Engineers Comments Regarding Surface Water Drainage

Application Reference:	Y/24/26/PL	Reviewer Reference:	ADC/ETX4b
Planning Officer:	Amber Willard	Date of Review:	18/08/2026
Site Name:	Sunnymead North End Road Yapton BN18 0DL		
Application Description:	Retention of fence at west of site on North End Road, hardstanding and access track and the creation of a residential caravan site with 3 No plots with associated parking, landscaping and facilities (resubmission following Y/57/24/PL). This application is a Departure from the Development Plan and is in CIL Zone 3 (Zero Rated) as other development.		
Assessment Number:	2

Reviewed Plans

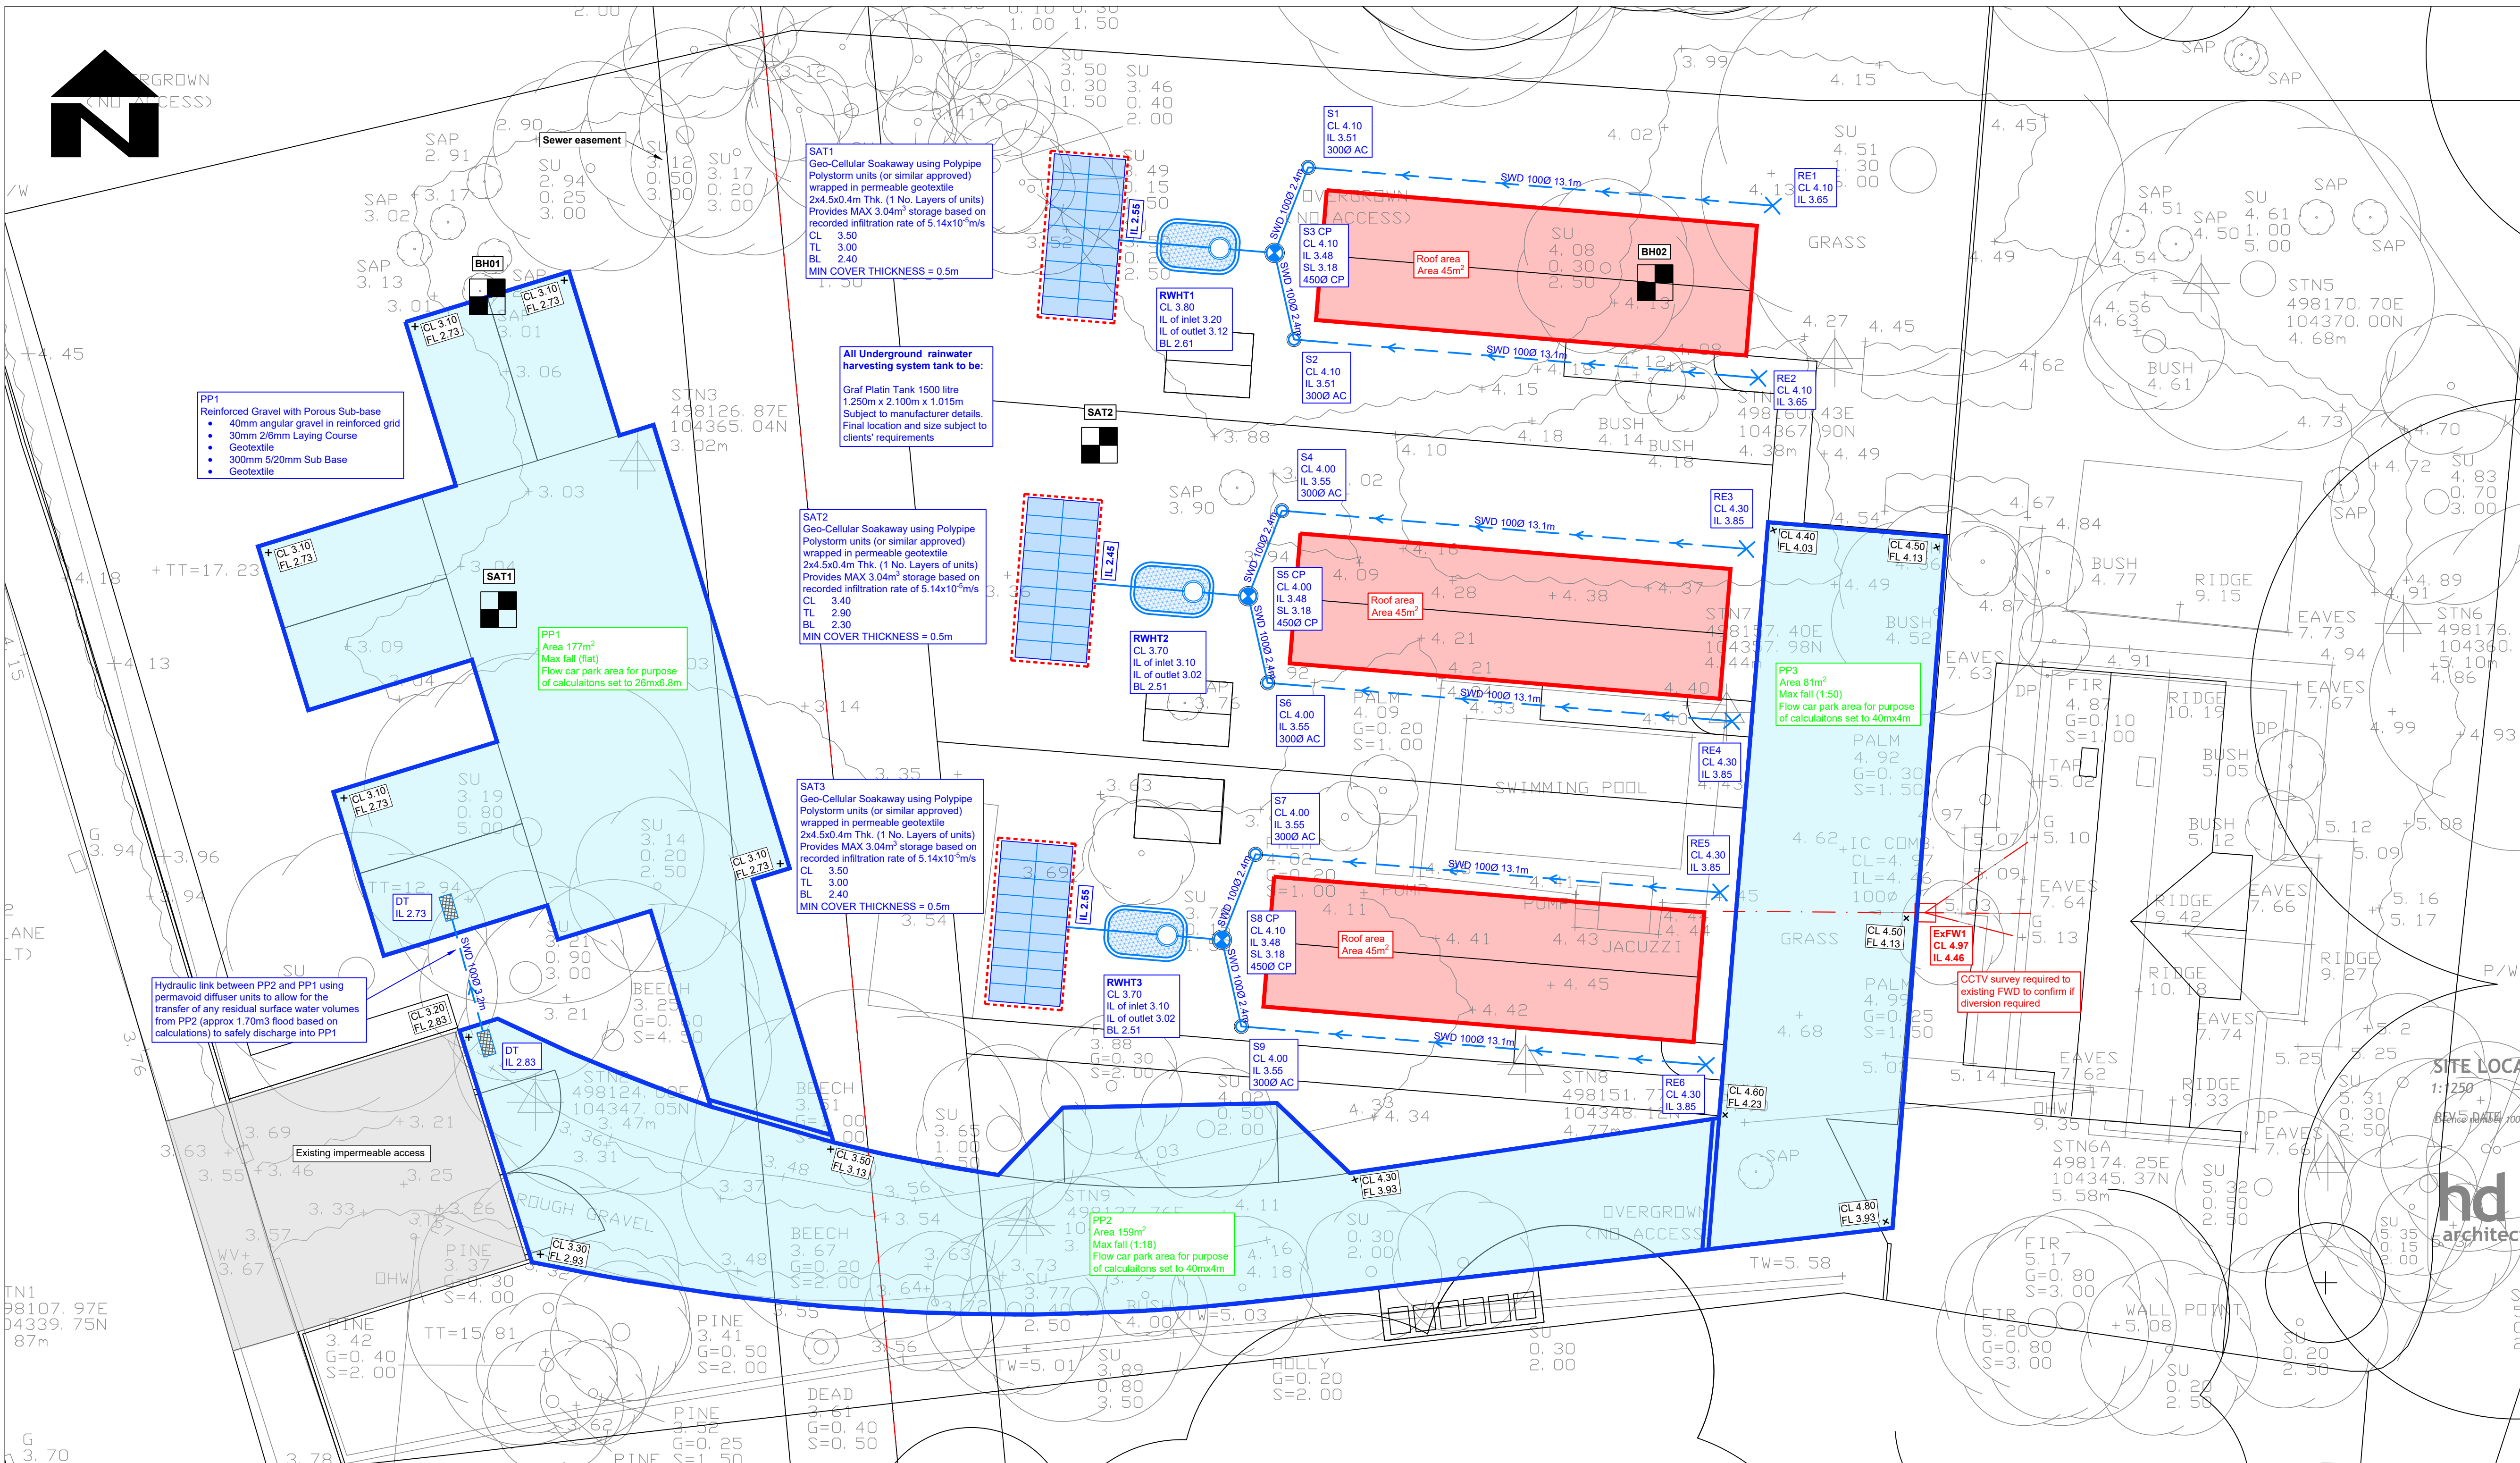
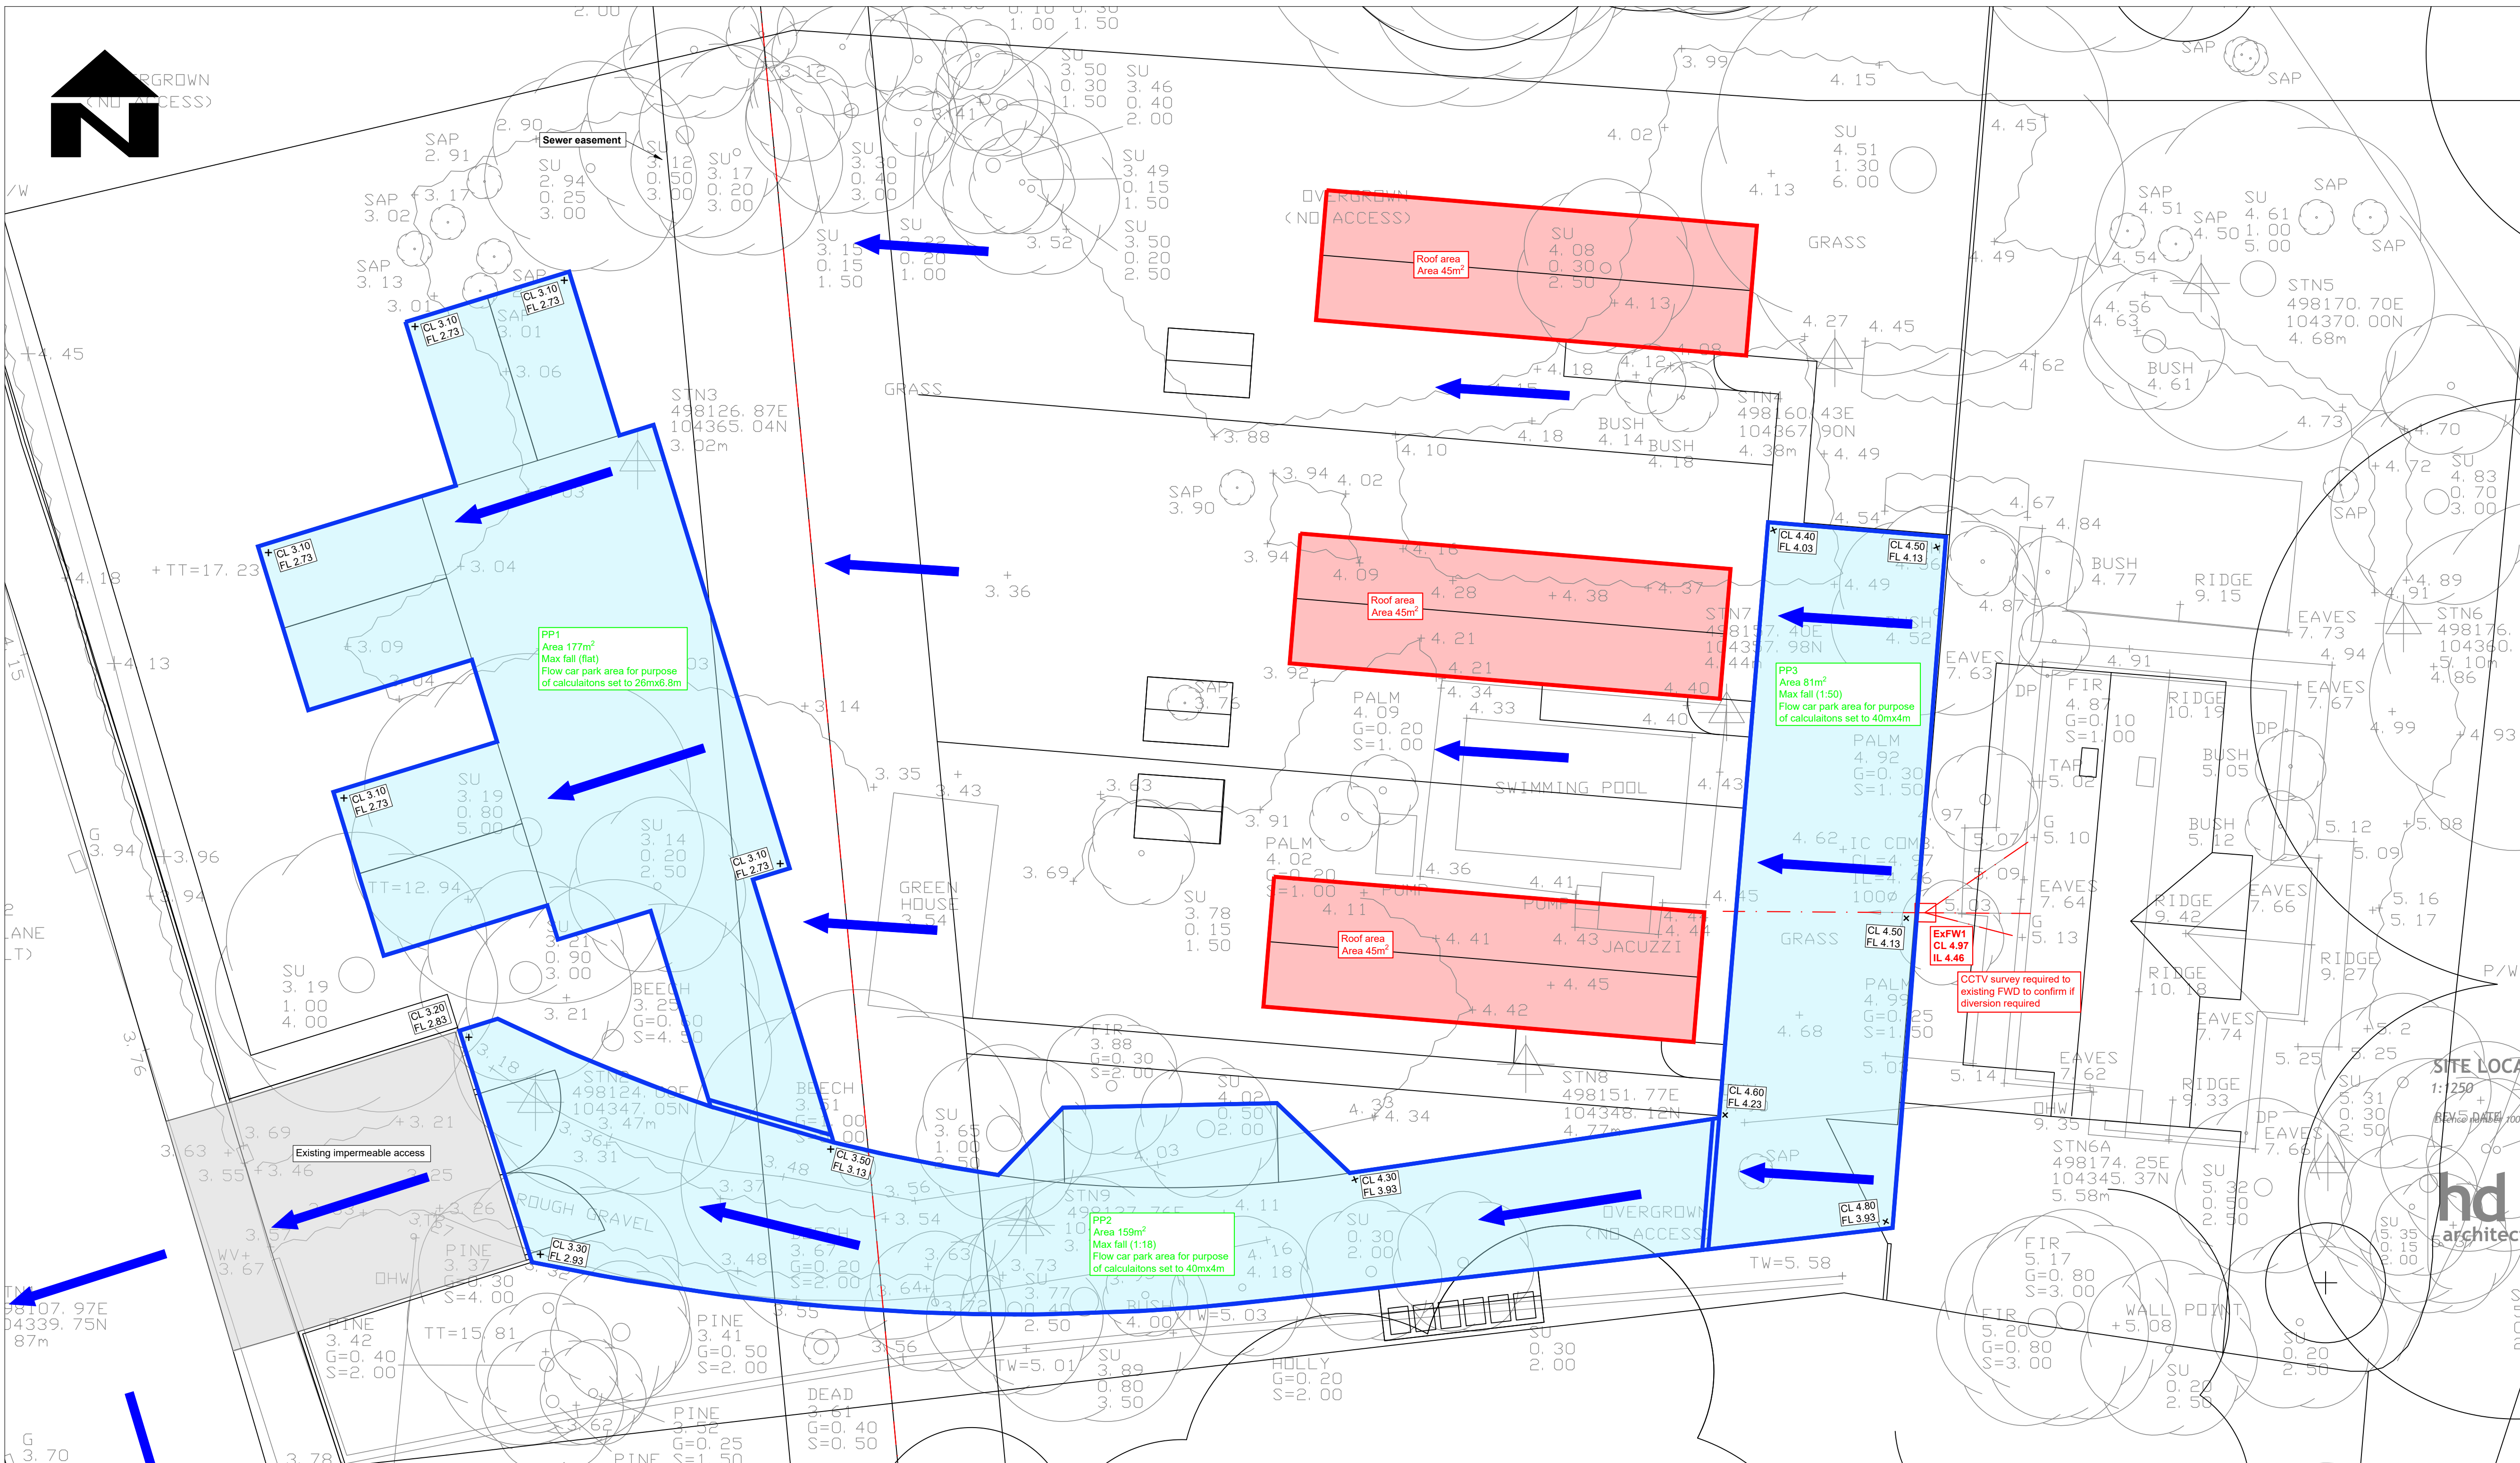
- 3.3. The design currently shows a hydraulic link between PP2 and PP1 – allowing areas outside of the Flood Area to drain into it. This would not be acceptable. However, if the permeable paving in the Flood Area is designed to only drain water falling on its own surface, then flood risk is assumed not to be increased by the proposal. This assumption is made on the basis that the raised surface levels of the parking will be accounted for by the flood compensation strategy (once updated). A detailed SuDS maintenance and management plan will have to be in place to ensure that the drainage system flood compensation area, and in particular the self-drained permeable paving, will be maintained for the lifetime of the development and can be remediated following flood events.
